Department of Transportation

December 14, 2021

SH 24G/94A
El Paso County

RE: Crossroads at Meadowbrook Filing No1 - SF2129

212 N. WAHSATCH AVE., STE 305
COLORADO SPRINGS, CO 80903
PHONE: 719.955.5485

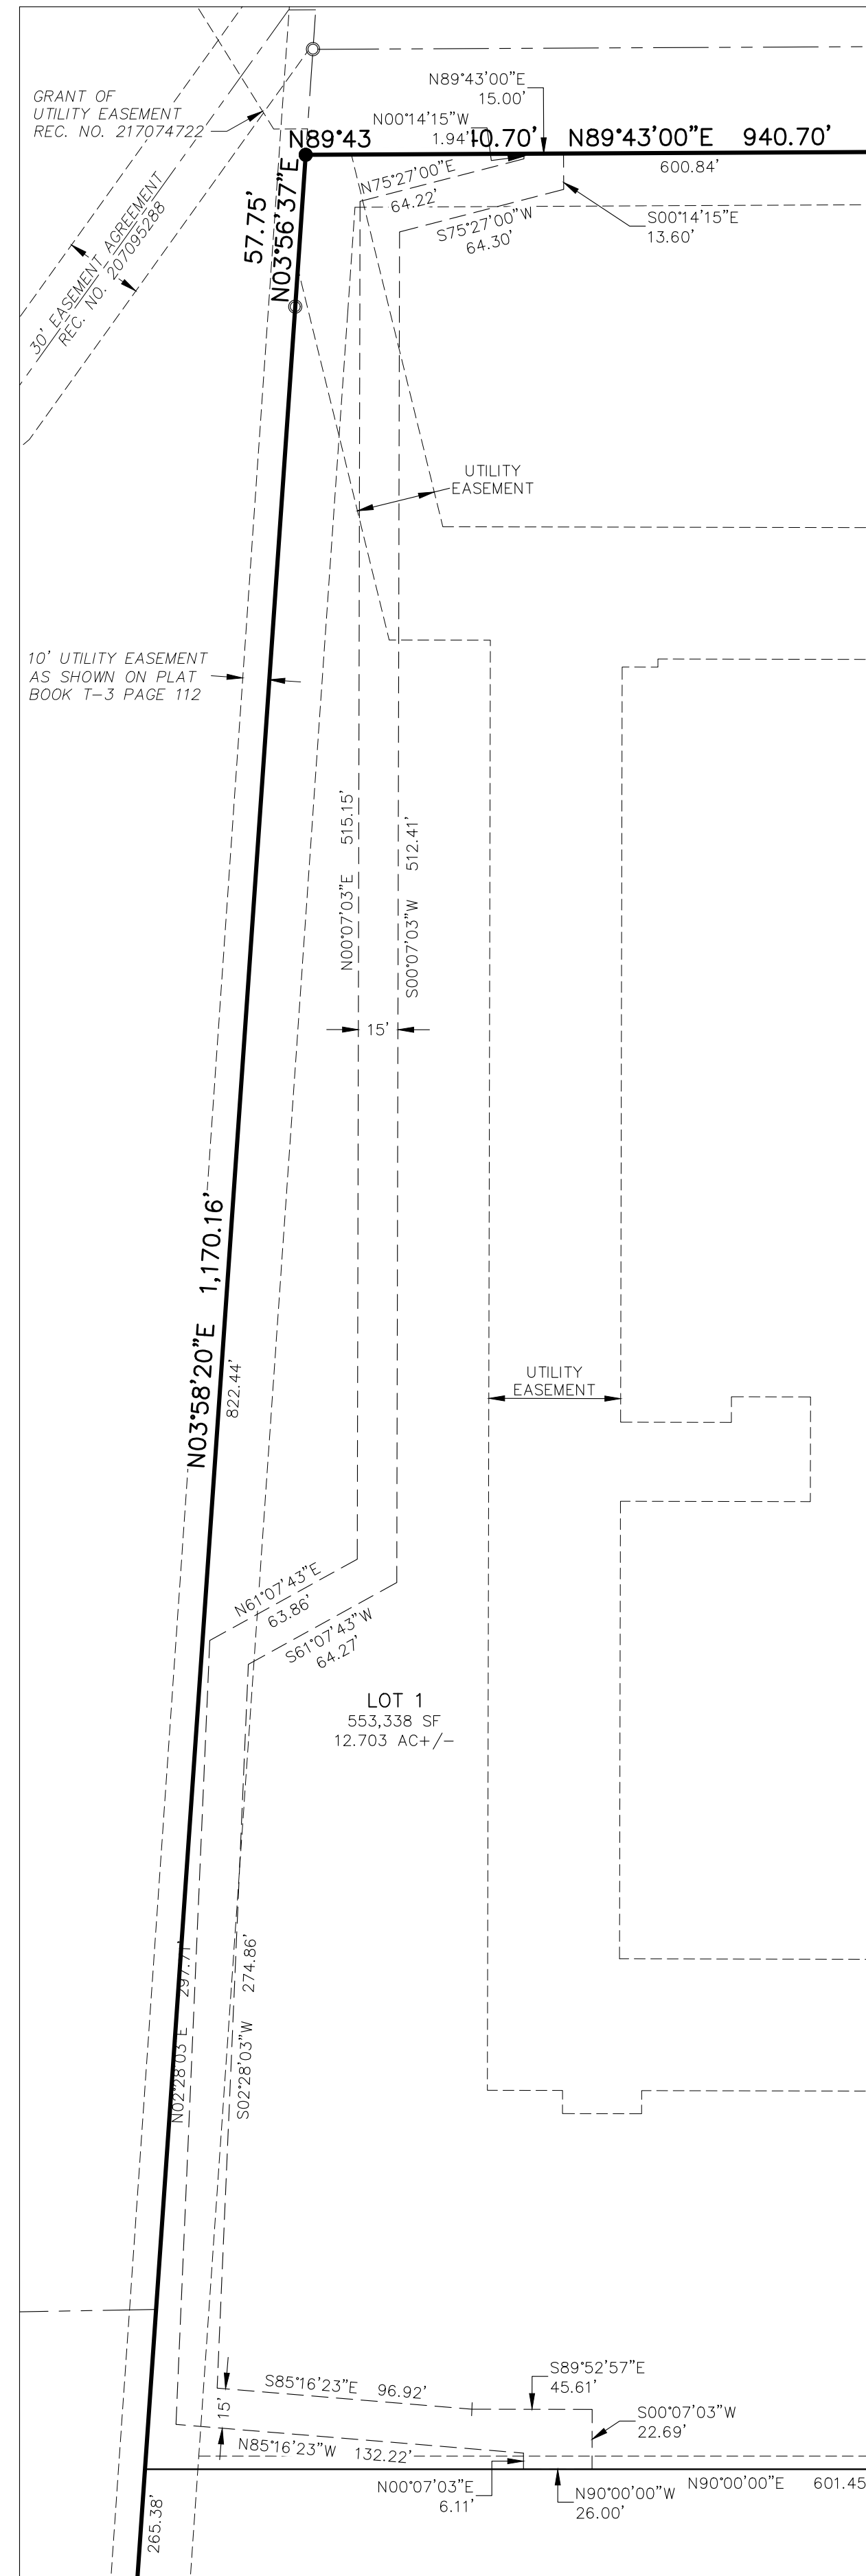
- **As has been previously stated the plan shall reserve public right-of way for the future interchange at US24 & 94. The plat, as submitted shows no reservation or ROW dedication.**
- CDOT is requesting ROW dedication along US24 south of the intersection of SH24 east and west side of the roadway and north of the intersection east and west side of the roadway for the footprint of the El Paso Counties PEL Study and for the expansion of US24 to include three thru lanes EB and one acceleration lane off of Newt.

- **The current Filing No. 1 Plat does not show dedication of ROW and will need to be revised and rereviewed.**
- The developer is required to apply for a new Colorado Department of Transportation Access Permit for the connection of Newt Dr. to SH24G. An Access Permit is required at the intersection location of (SH24 and Newt Drive). The change in land and access use rules apply as detailed in the State Highway Access Code 2002, Section 2.6. **This has not been done to date.**
